Cur Case Number: ABP-314942-22

Re: BusConnects Lucan to City Centre Core Bus Corridor Scheme
Lucan to Dublin City Centre

Ref: Bus Connects Dublin, Core Bus Corridors Infrastructure, Lucan to City Centre Scheme

Drawing File Name	BCIDA-ACM-ENV_LA-0006_XX_00-DR-LL-0015	Sheet Number	15 of 31	Status	A	Rev	M01
-------------------	--	--------------	----------	--------	---	-----	-----

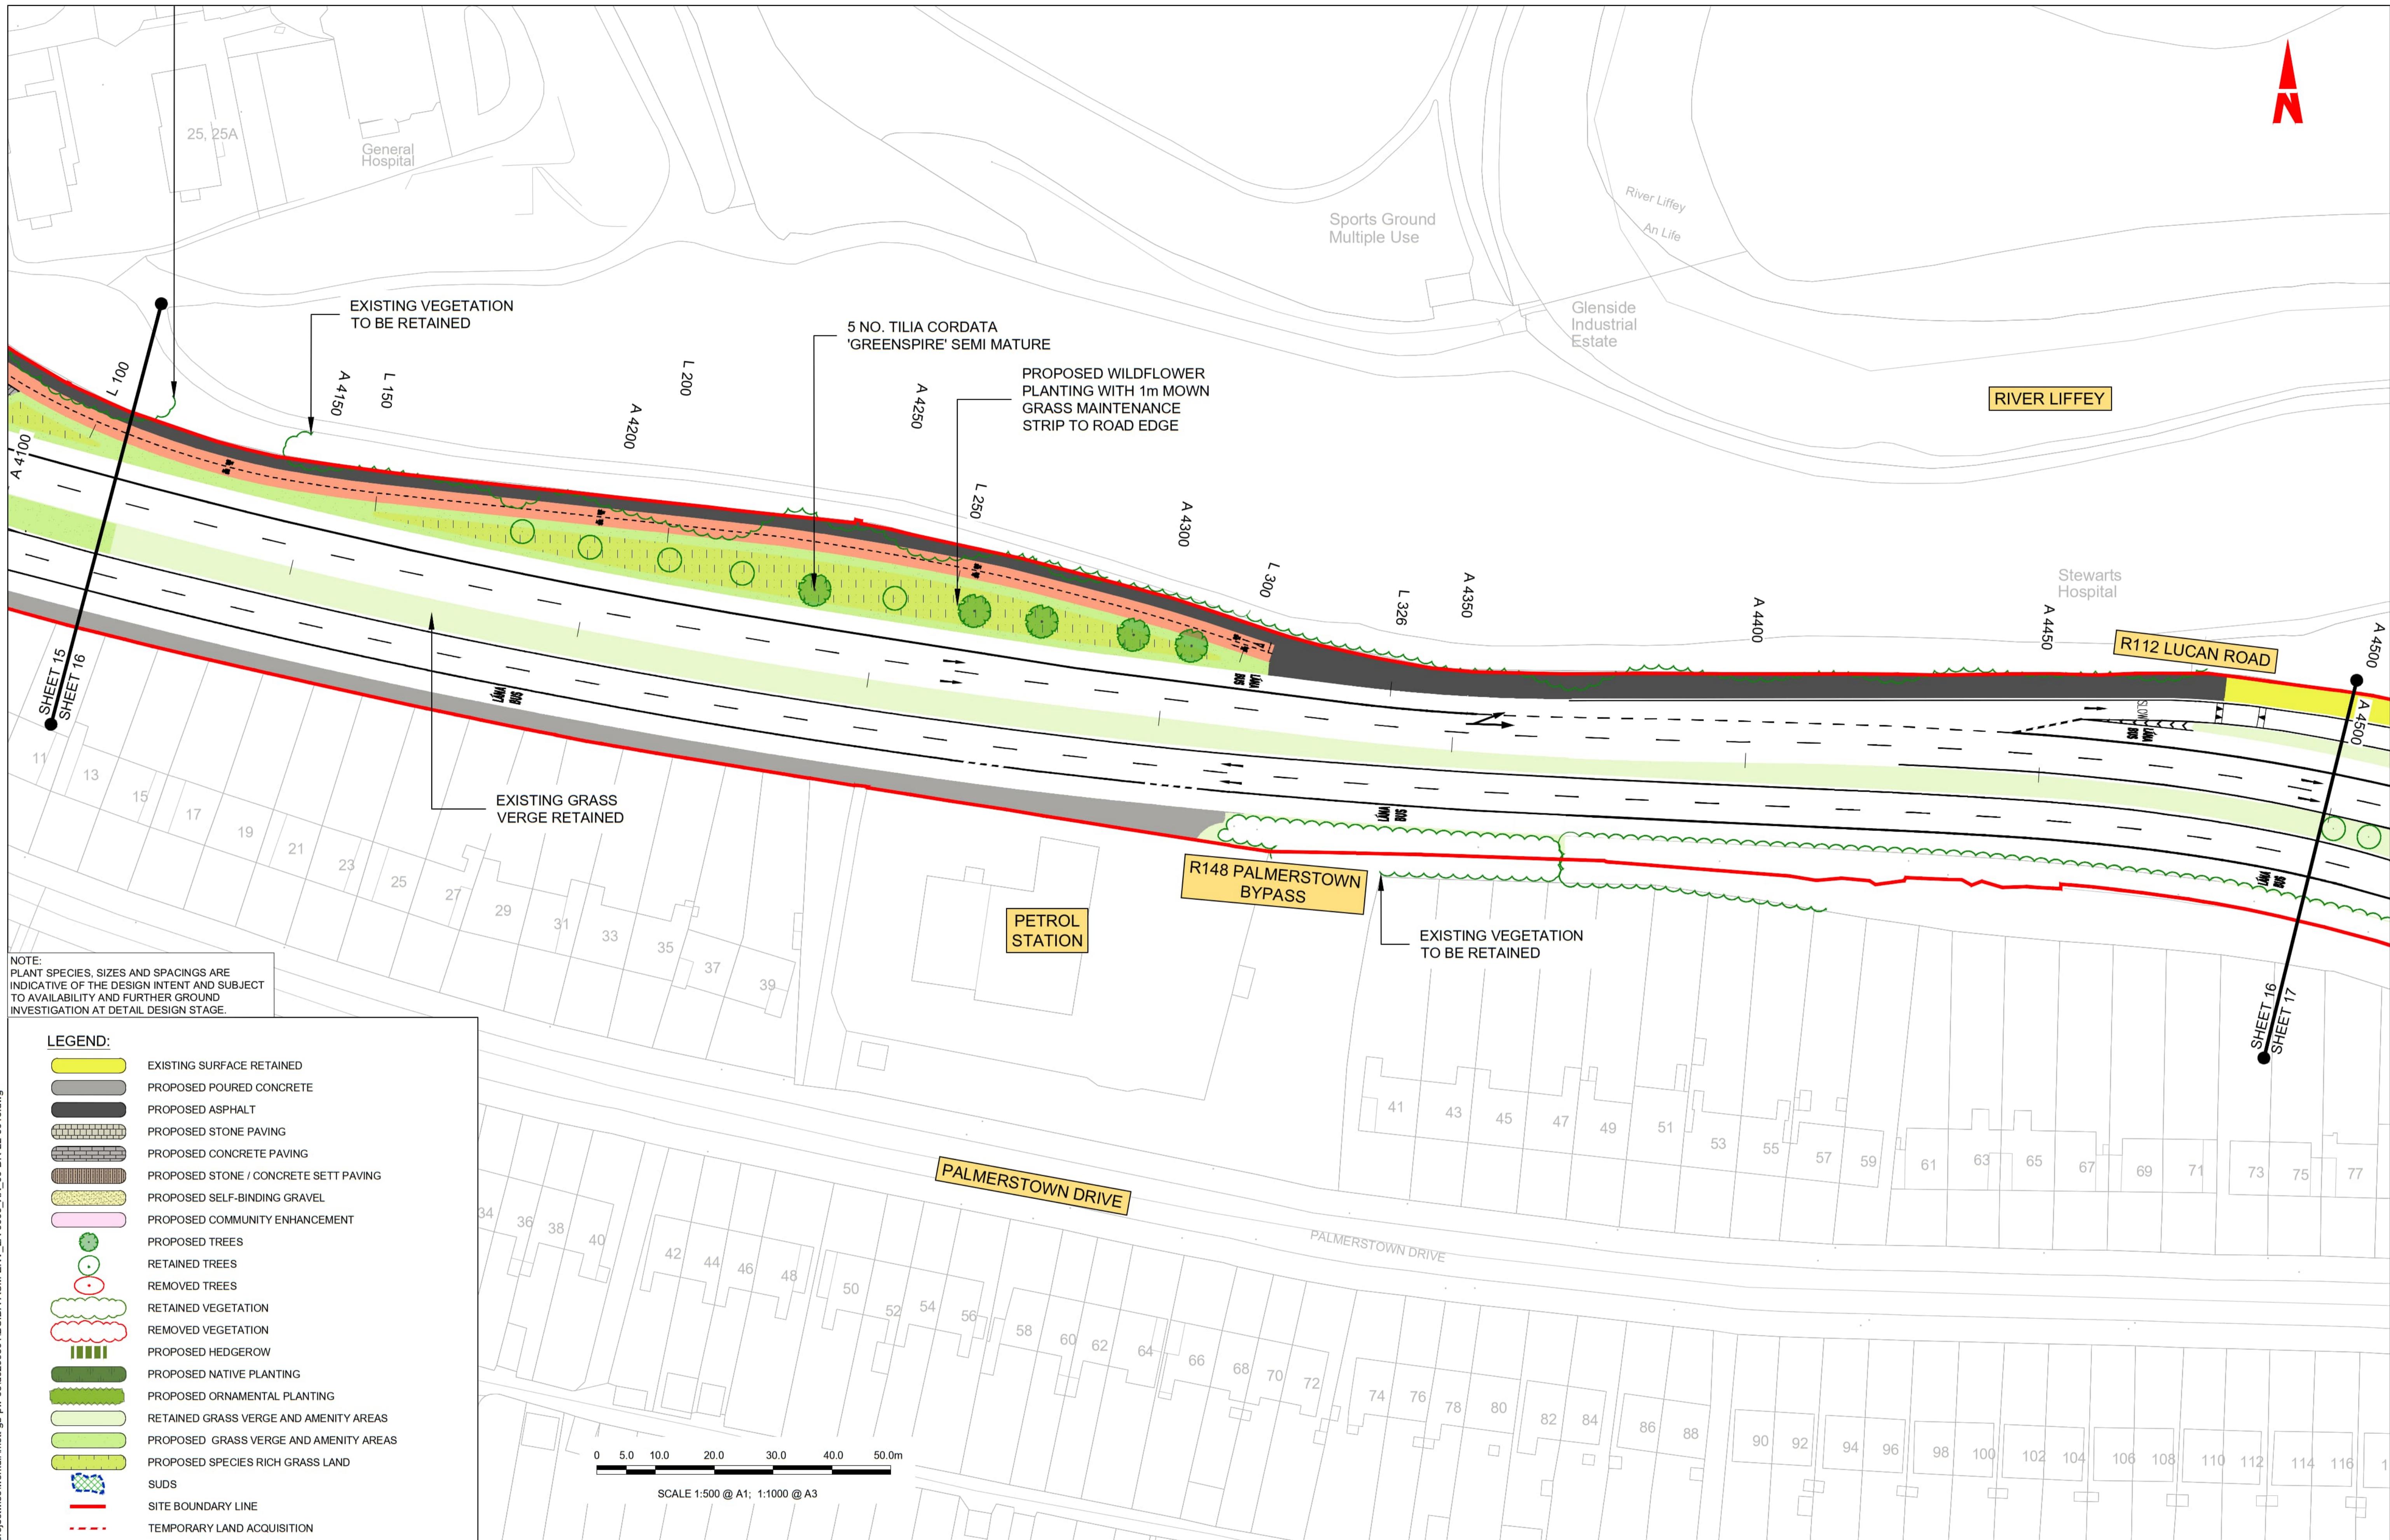
Of particular concern is the use of a green area to the north of the R148 for a construction compound and plant storage. This it would seem would involve the removal of mature Beech trees in this area. On drawing DRLL0015 sheet 15 of 31 it indicates the removal of 5 of these trees. However, the Arboreal drawings DR ES 0014 sheet 14 of 31 shows no such indication of the removal of these trees. This error is misleading and should be subject of a revision of the drawings and a further information request to clarify which is correct. These beech trees form a very important visual and environmental function on this stretch of roadway and many residents do not wish these valuable trees to be removed, even with replacements planned in the future.

There is a badger sett in this area and badgers have been actively living in this here and the adjoining gardens for many decades and form a vital part of local biodiversity. If any work is to be carried out in the vicinity of this sett, the utmost care should be taken not to disturb collapse or otherwise interfere or disturb this community of badgers. Hedgehogs are also present in this area and use the overgrown verges for foraging and as hibernation sites, as per the point above if this land is to be used the edges should be left undisturbed. Bats are regularly seen here also and in the beech trees mentioned above. All efforts should be made not to disturb or damage roosting sites or food sources.

If an alternative compound can not be identified we would ask that a full environmental survey be undertaken, in consultation with residents and any and all measures be taken to protect and preserve the wildlife flora and fauna in this area.

A detailed plan should be drawn up and made available to the local community as to the specification of materials used to for a compound, ie will there be a new hardstanding surface laid? Will this be fully removed and high-quality topsoil reinstated. What security measures will be in place to discourage the inevitable break ins which will occur and the knock-on effect and security risk to the rear of houses at Red Cow cottages. Will there be floodlighting for 2 years which not only will disturb residents but also the local wildlife.

We recommend that an alternative location be found, one that has existing hardstanding, lighting, and no existing trees or wildlife.

| Drawing File Name: BCIDA-ACM-GEO_GA-0006_XX_00-DR-CR-0014 | Sheet Number: 14 of 31 | Status: A | Rev: M01 |

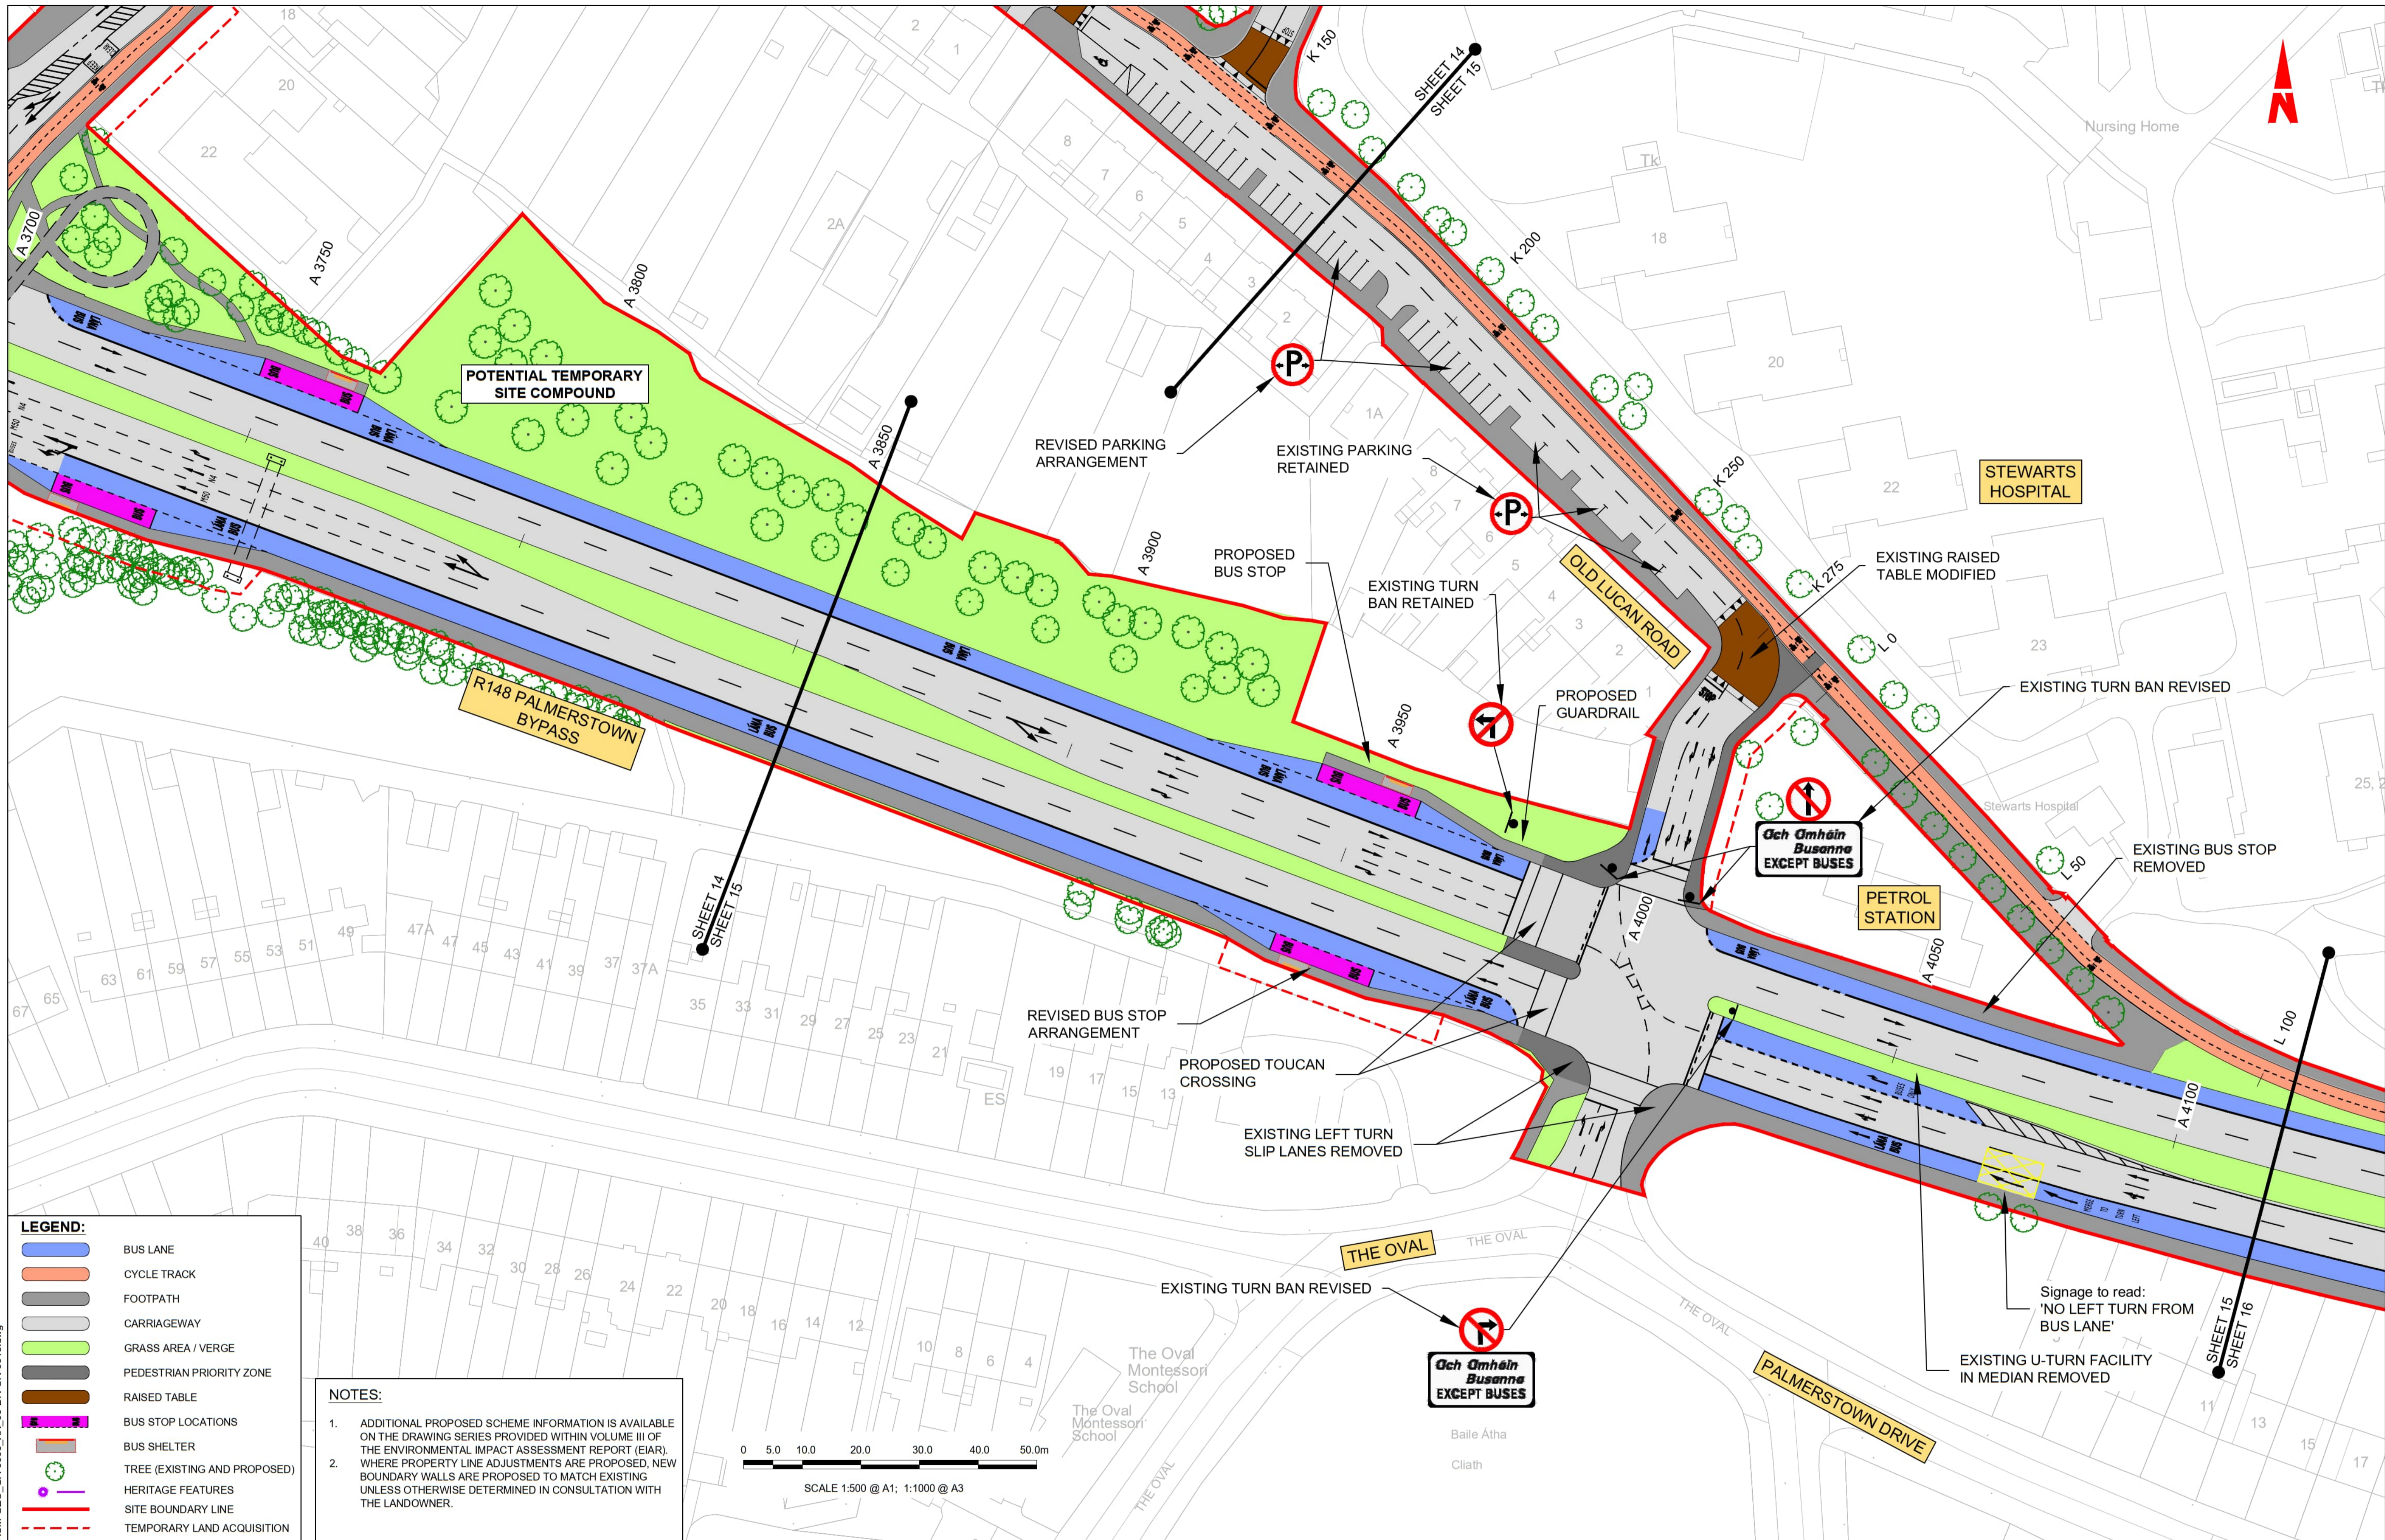
I am writing to you to make observations on the above application scheme particularly as it relates to the Palmerstown Village portion of the project. Referenced mainly by drawings DR-CR-0014, DR-CR-0015, DR-LL-0014, DR-LL-0015, DR-ES-0014, DR-ES-0015 and related documents.

We would request a Further Information on the exact materials to be used to make all of the changes proposed, cycle lane surfacing, raised tables, and all street furniture etc. The historic importance of old Palmerstown must be protected. In recent years it has been eroded more and more and its specific historic character is being lost. We particularly would be against excessive bollarding of cycle lanes which is a blight on the whole city at present, turning many areas of our city into a visual mess subtracting from areas of architectural importance.

The potential siting of a bus stop in front of RedCow cottages will detract from this architectural vista, this location should be revised. The overall choice of materials needs careful consideration and no such specification is currently in the documentation.
